From: Elaine Walby <Elaine.Walby@arun.gov.uk> **On Behalf Of** Planning
Sent: 19 March 2026 11:04
To: Planning.Responses <Planning.Responses@arun.gov.uk>
Subject: FW: Planning Application R/31/26/HH . 15 Evelyn Avenue, Rustington, BN16 2EJ.

From: [REDACTED]
Sent: 18 March 2026 17:12
To: Planning <Planning@arun.gov.uk>
Subject: Planning Application R/31/26/HH . 15 Evelyn Avenue, Rustington, BN16 2EJ.

Further to my previous email regarding planning application R/31/26/HH. 15 Evelyn Avenue, Rustington BN16 2EJ

Rev	Notes	Date
 M: 07599199759 E: info@nat-design.co.uk www.nat-design.co.uk		
Project:		
15 Evelyn Avenue Rustington BN16 2EJ		
Drawing:		
Proposed Elevations		
Drawn by NSE		Scale as shown
Date Feb 2026		Revision
Drawing		
2027 - DPA - 06

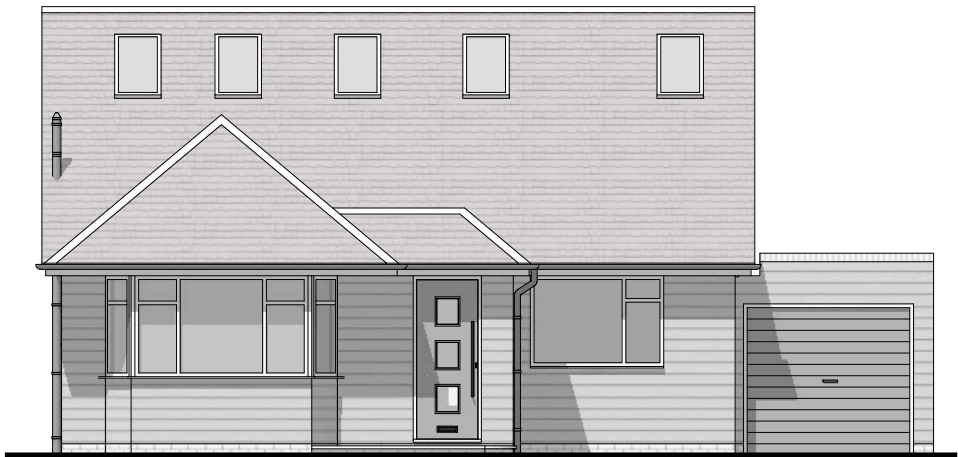
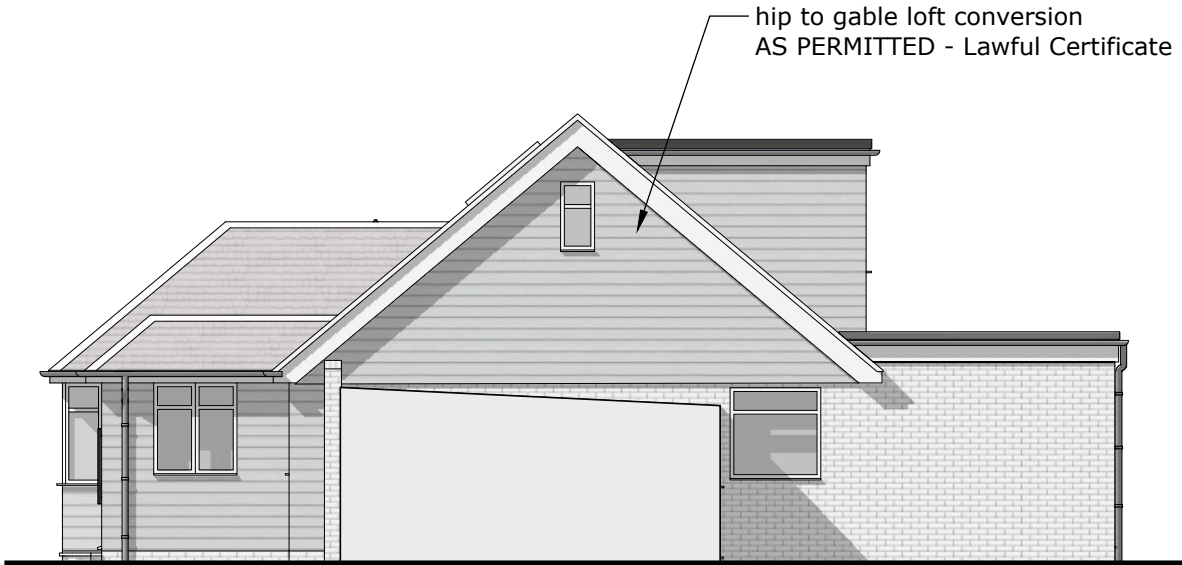
I wish to express my great worry and concern as to how overbearing the proposed extensive full property width rear dormer windows would be. My bungalow is only two meters away from the south side hip to gable large extension.
I would experience a tremendous loss of light and privacy.
